Planning Application Ref: EG/71/18/T

Location: Oakside, Old Rectory Drive, Eastergate, PO20 3XH

Description of works: Reduce crown to previous pruning points to 1 No. Oak tree.

Sketch plan, not to scale

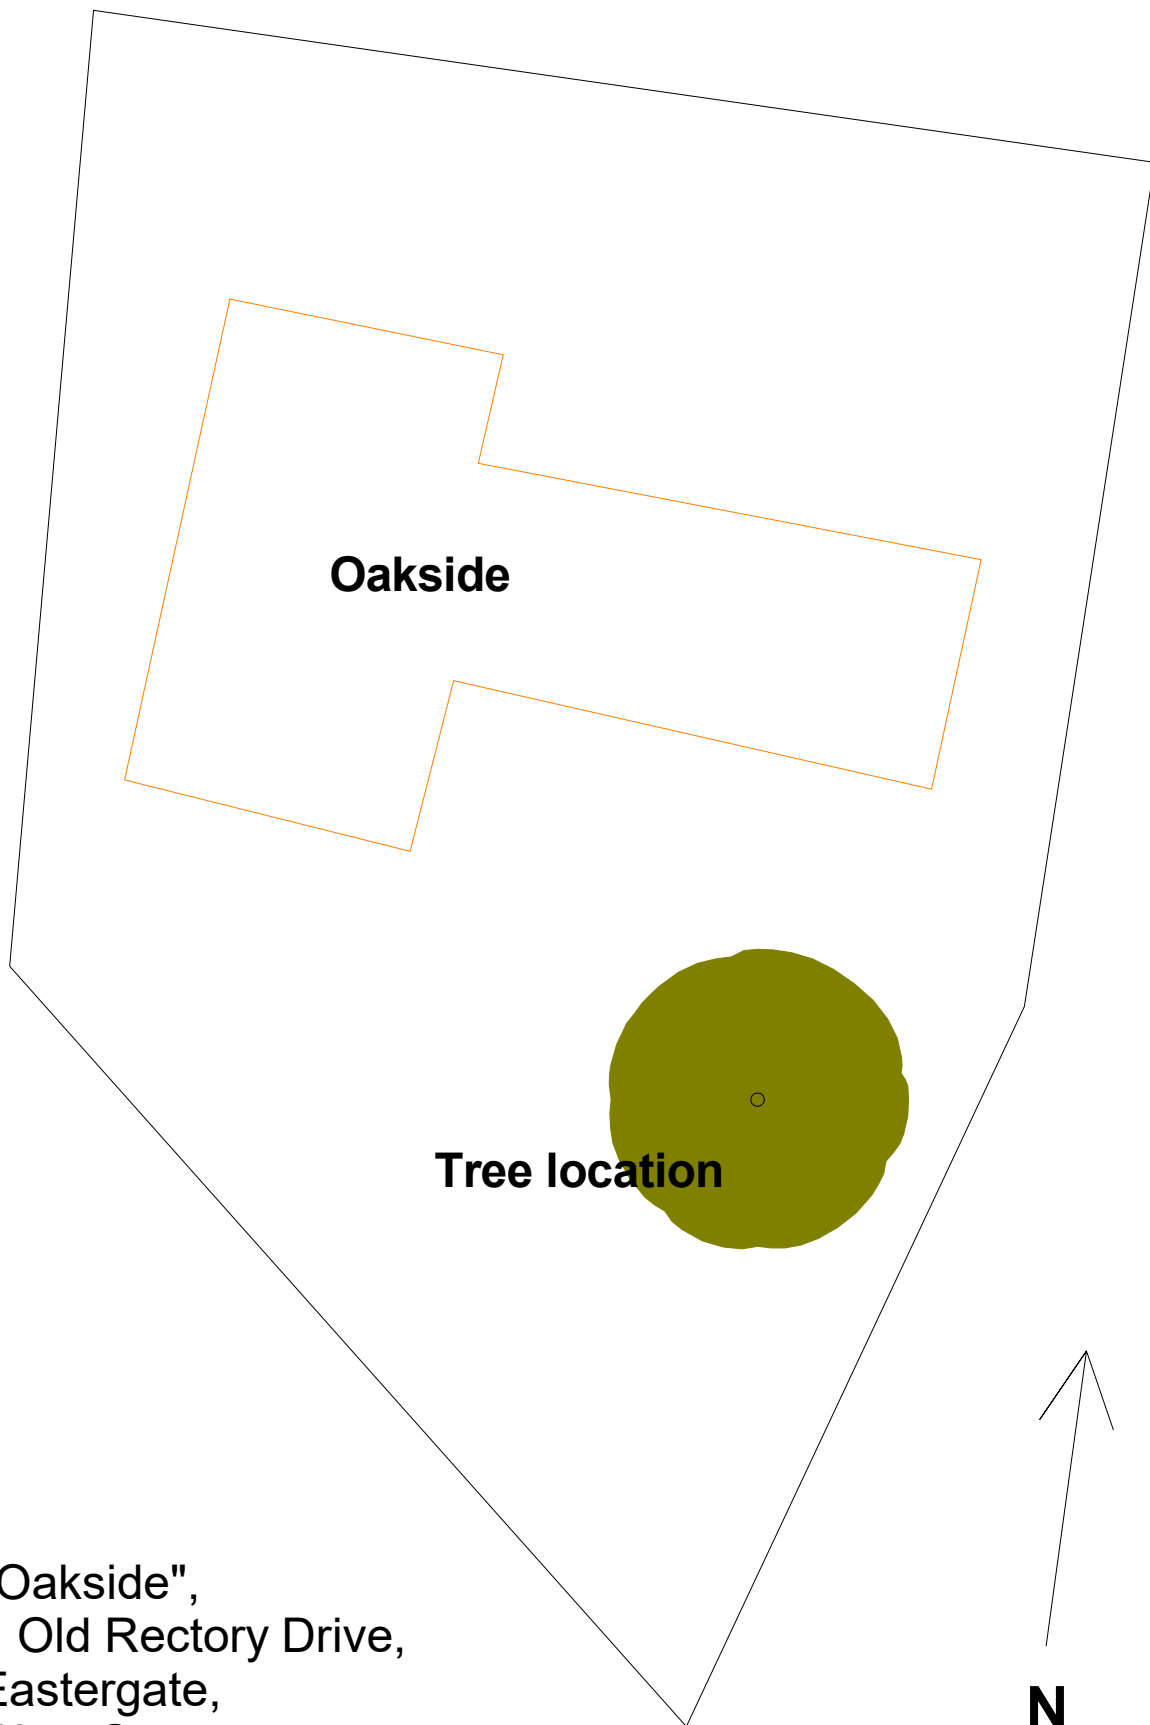
- This tree has previously been the subject of substantial crown reduction work (c2009) and approved by the Local Planning Authority. This was in response to the findings from a detailed decay investigation undertaken by a consultant arboriculturist, expert in this field of work.
- This latest application is supported by a detailed Arboricultural Report from Phillip Ellis, which is comprehensive and informative, such that I do not need to assess the tree for myself.
- This is clearly a valuable tree although it has a multitude of defects and requires careful management to preserve it with dignity and in a state appropriate for its location.
- This large tree is a major constituent of the high canopy in this locality. It grows from the rear of the property and can be seen from adjacent properties and the public highway.

- Work proposed is necessary to mitigate an evidenced risk of structural failure and so justified on arboricultural grounds.
- The proposal to repeat crown reduction work is consistent with previous works approved by the Local Planning Authority.
- There will be a slight (and hopefully temporary) reduction in the tree's amenity value, which is an unavoidable consequence of this work.

- I recommend **CONSENT** for this application, subject to the following condition:

- The removal of crown material which has developed since the last operation must be done sympathetically and with respect to established 'knuckles' so as not to extend beyond the point of origin.
- The long-term vitality of this tree is best respected when significant pruning work such as proposed, is undertaken during either the mid-summer (mid-June to mid-September) or mid-winter (mid-December to mid-February) periods.
